Mount Piper to Wallerawang Transmission

The Department of Planning, Housing and Infrastructure – Crown Lands (the department) has reviewed the proposal.

FIGURE 8 - Key project elements

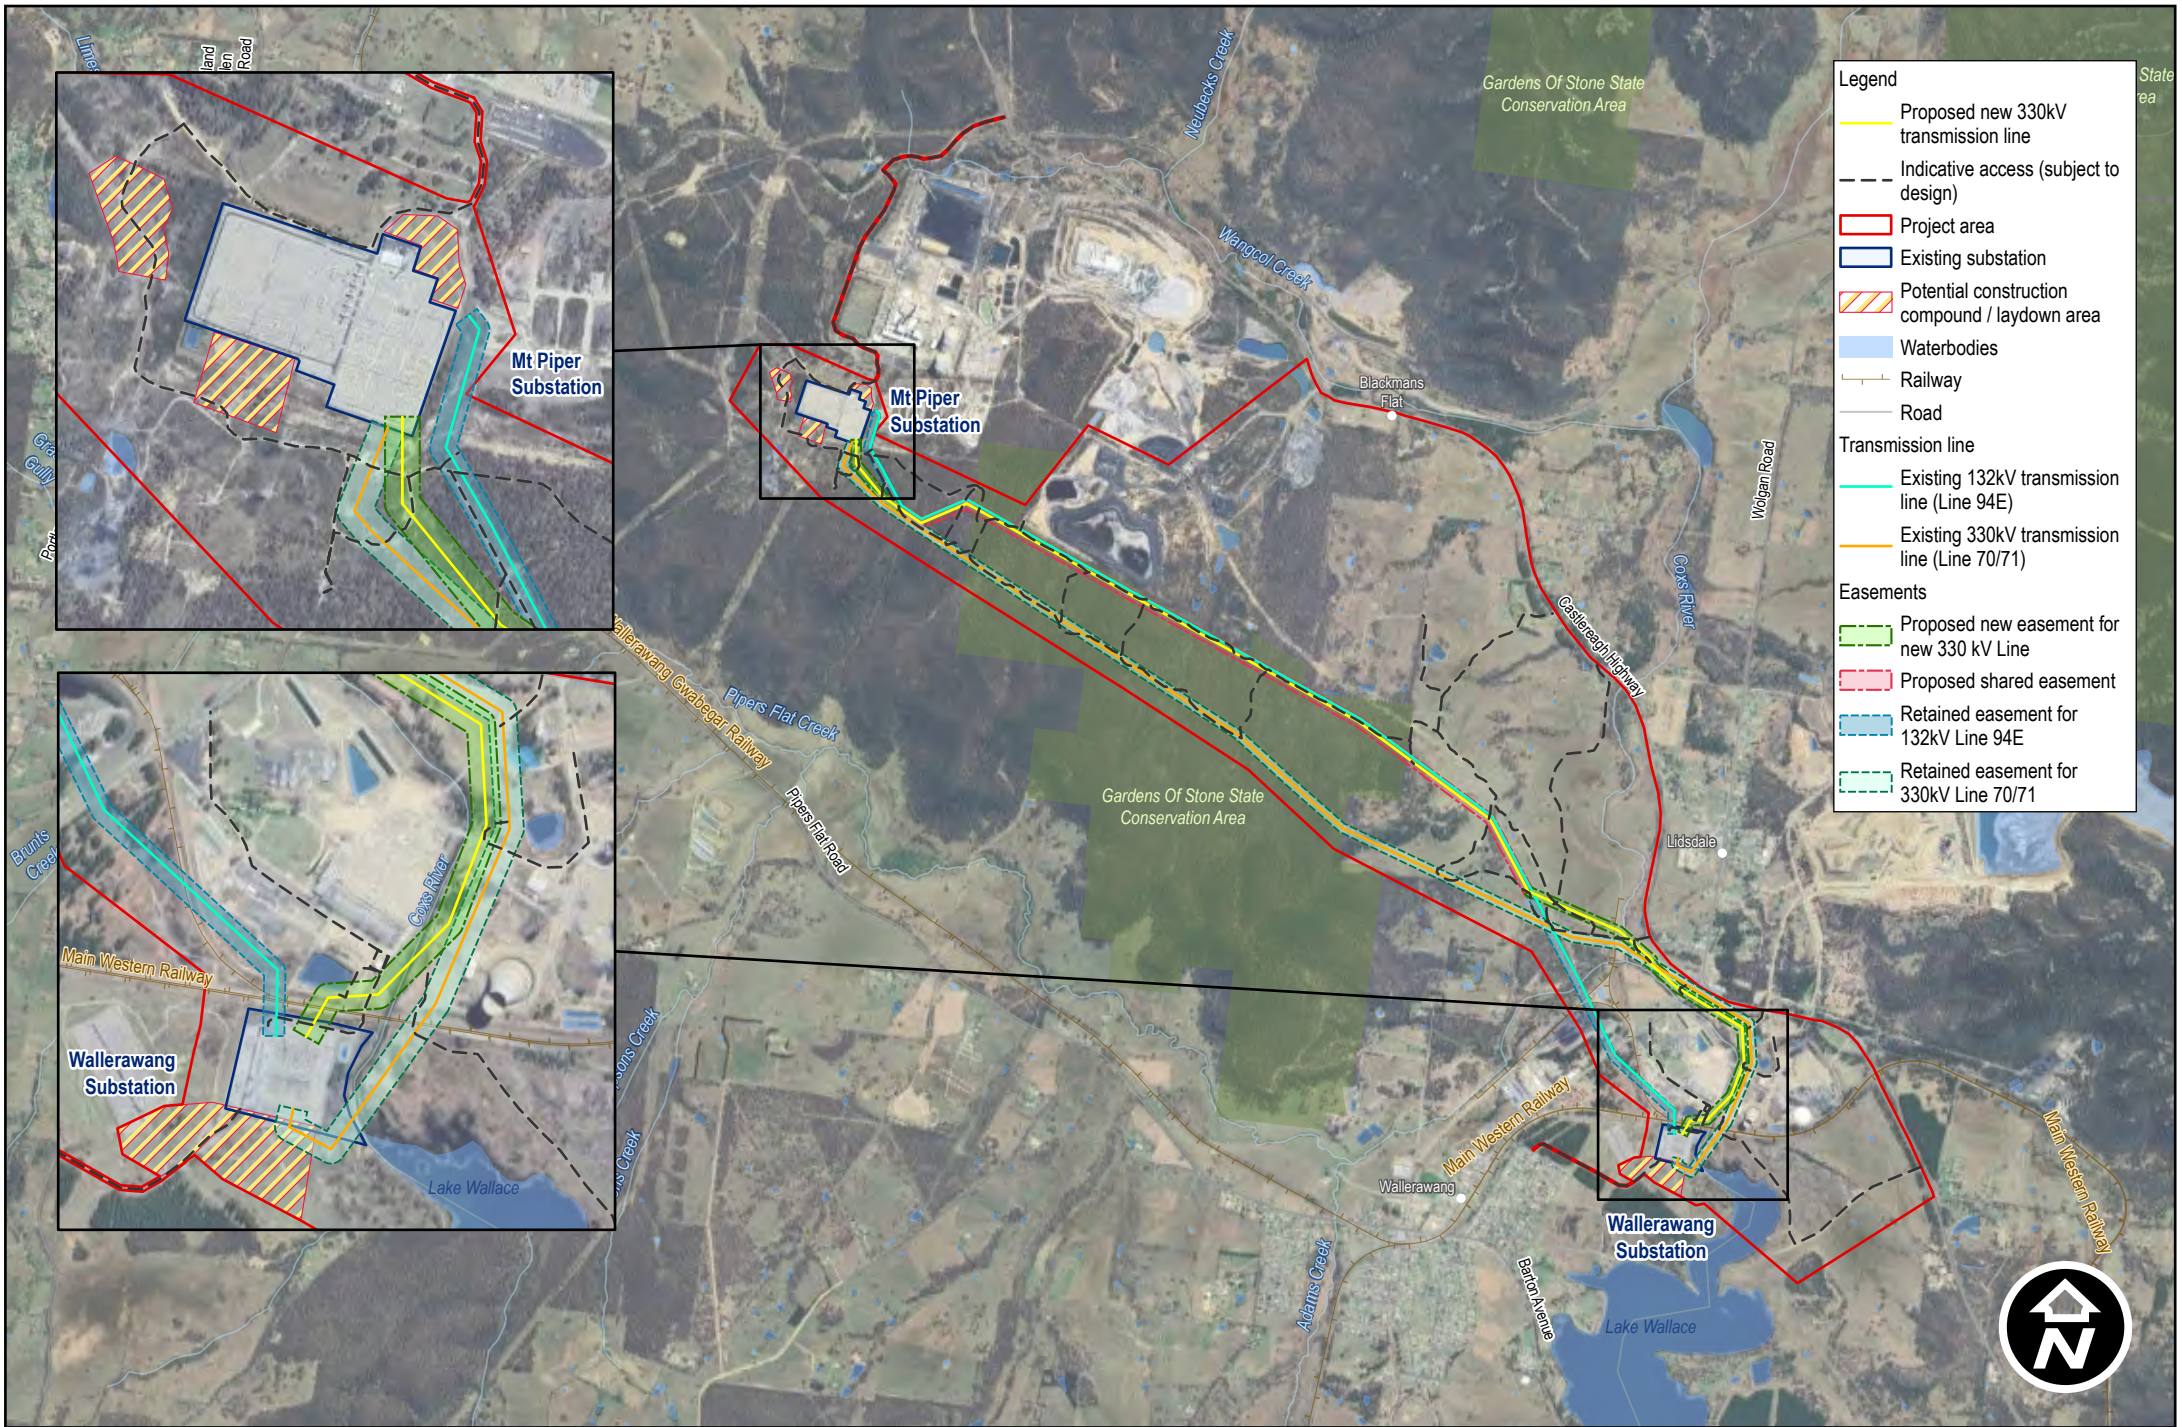
Diagrams within this report (- Figure 2, Figure 8, FIGURES 9A-F) show the preferred Option B-4 for the new transmission 330kV transmission line, and the 60m wide easement that it will require. These intersect with two current unnamed Crown roads and the Crown waterway, Cox’s River.

As lineal infrastructure (such as pipelines and/or electricity transmission lines) are expected to traverse Crown land, roads and waterways, an easement over said Crown roads and waterways will be required for protection of the infrastructure.

To discuss easement requirements, please contact the Acquisitions team at the earliest opportunity at: cl.acquisitions@crownland.nsw.gov.au.
